About the application

Application number: 2020/92331	
What is the application for?:	Outline planning application for demolition of existing dwellings and developmen
Address of the site or building:	Land east of, Leeds Road, Chidswell, Shaw Cross, Dewsbury
Postcode:

Type of comment: An objection

Client:	The Church Commissioners	Job No:	18,006
Project:	Chidwell Masterplan		
Title:	Parameter Plan - Development Area & Use		
Date:	21/03/19	Scale:	As indicated BA1
Checked by:	RG	Drawn By:	DH
Drawing No:	00-201	Revision:	F

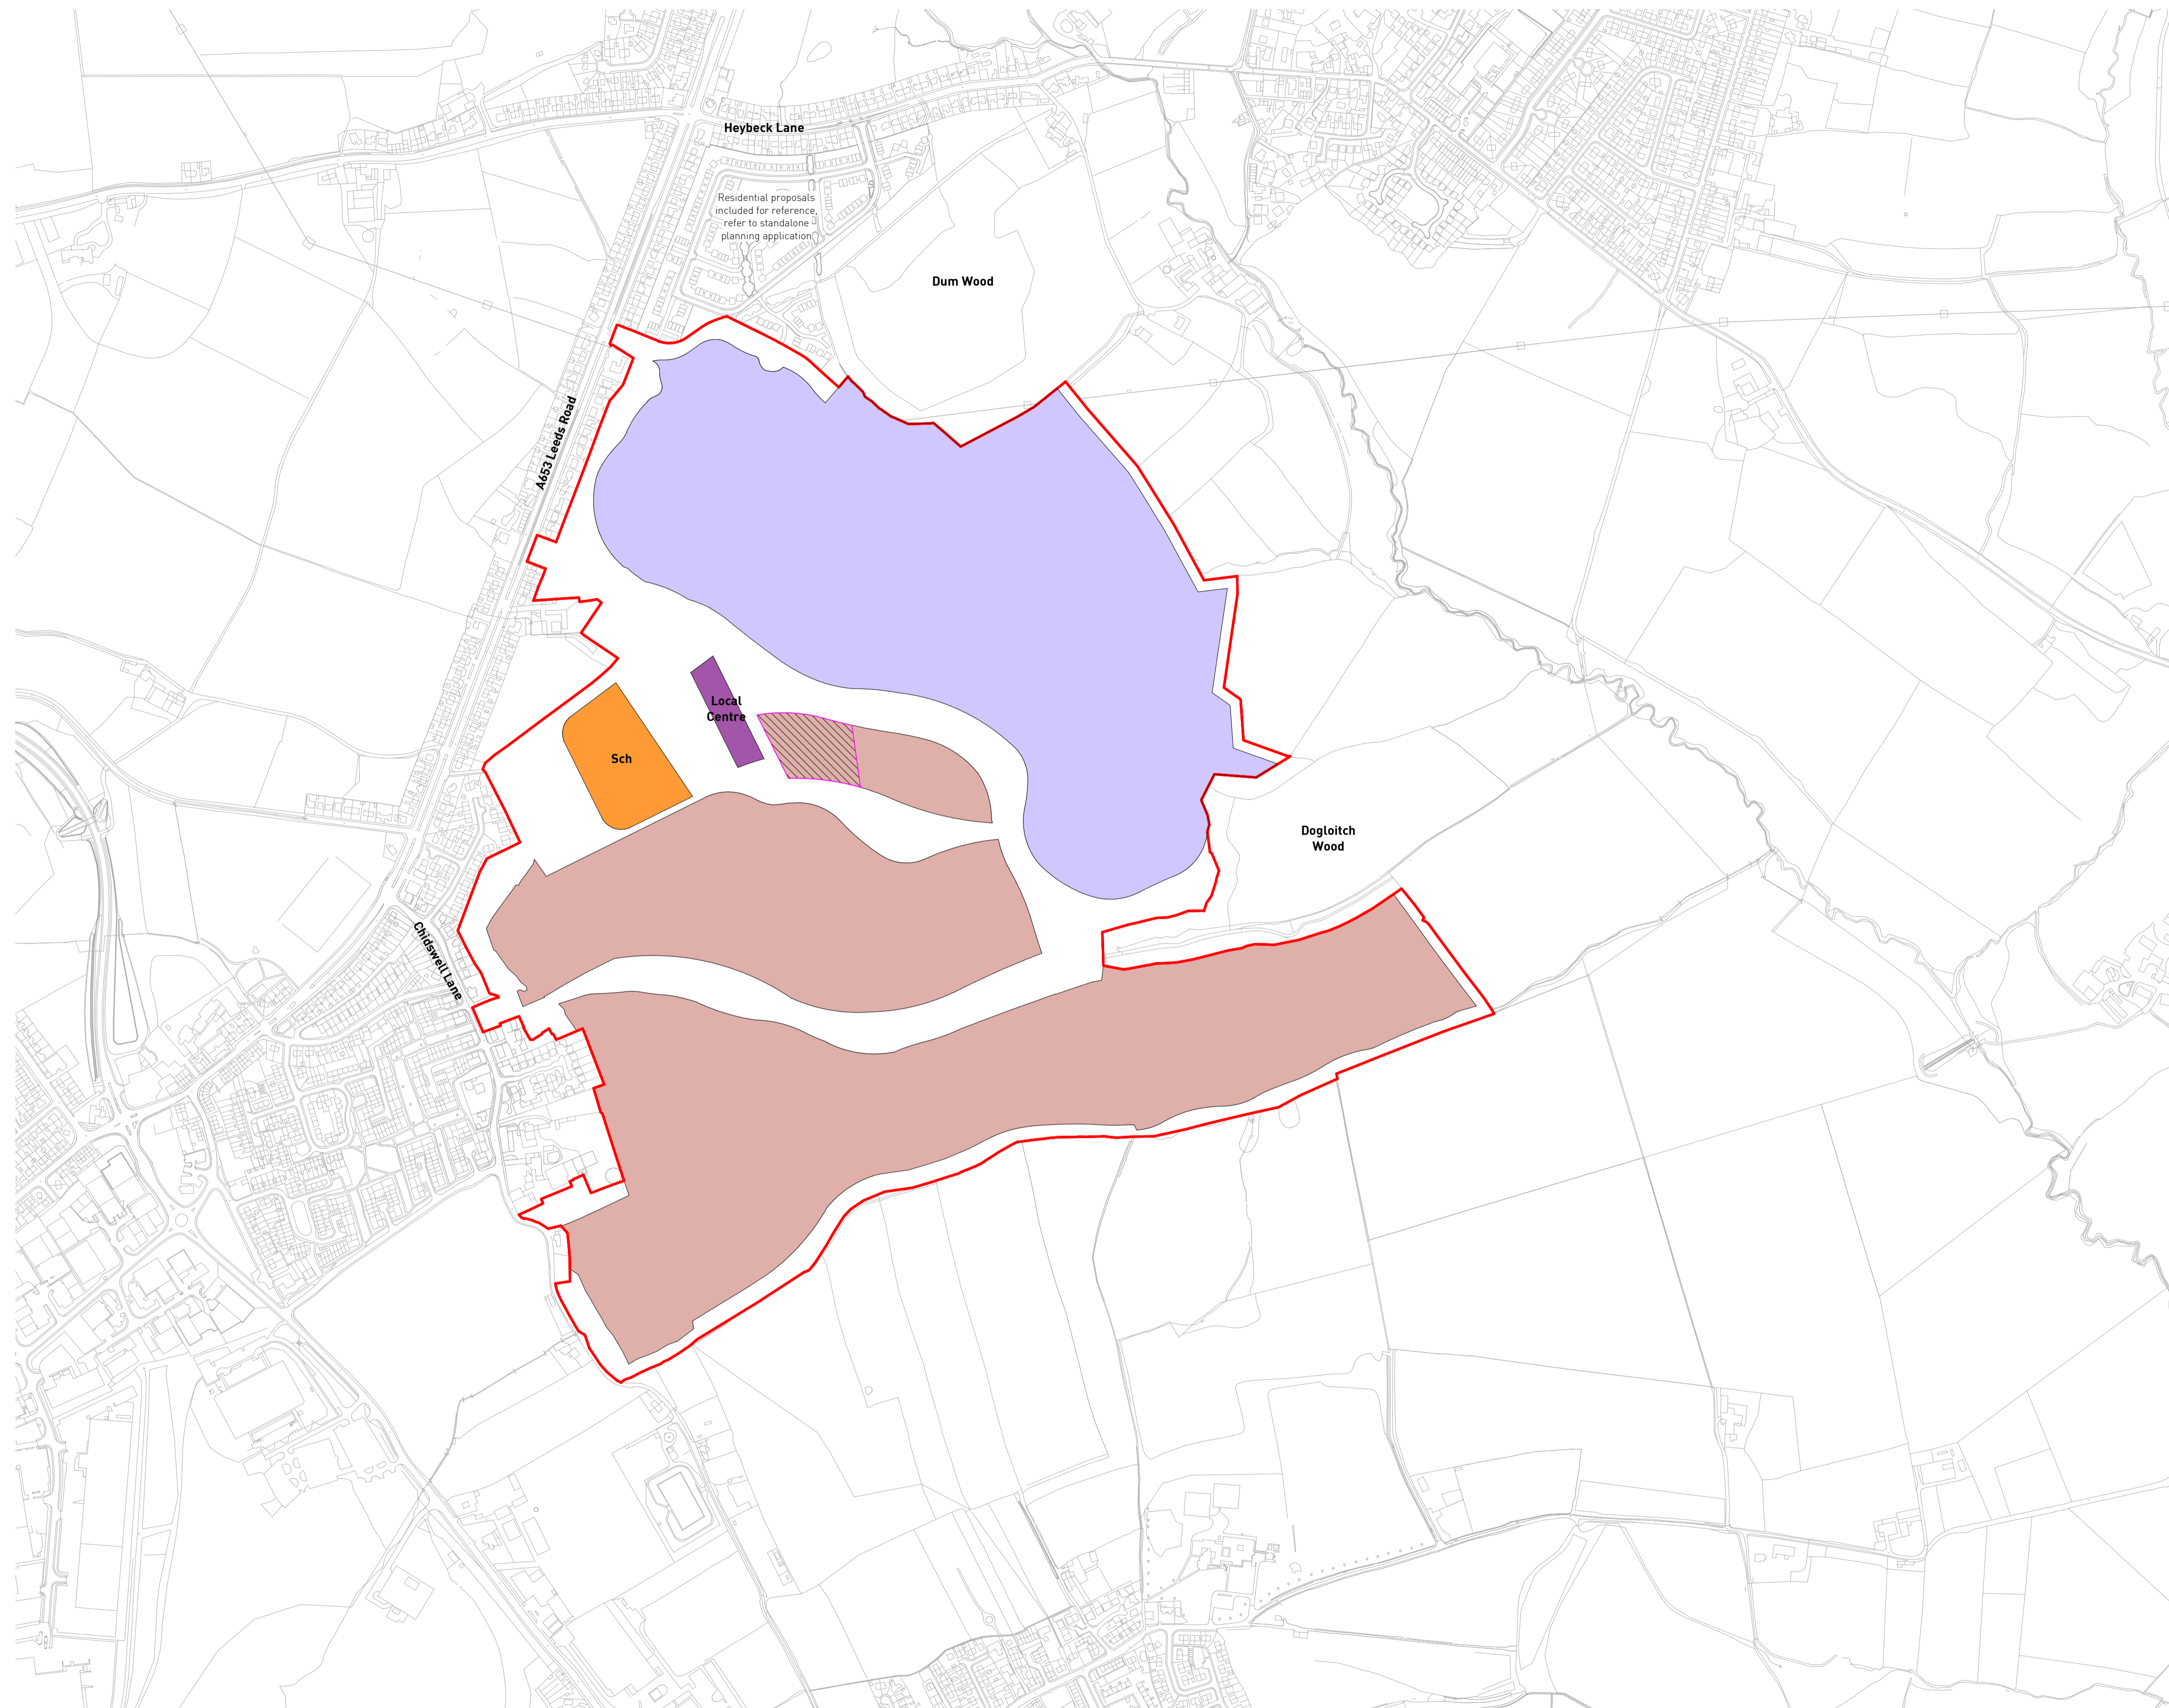
- The masterplan as it stands is not an example of good design as it creates a lack of connection between areas of development. The industrial buildings are set between areas of proposed housing and infrastructure (e.g. school). Thereby, creating an isolated island of unrelated and segmented built form which has no spatial or character connections either to other areas of proposed development or the current settlement pattern and landscape setting.
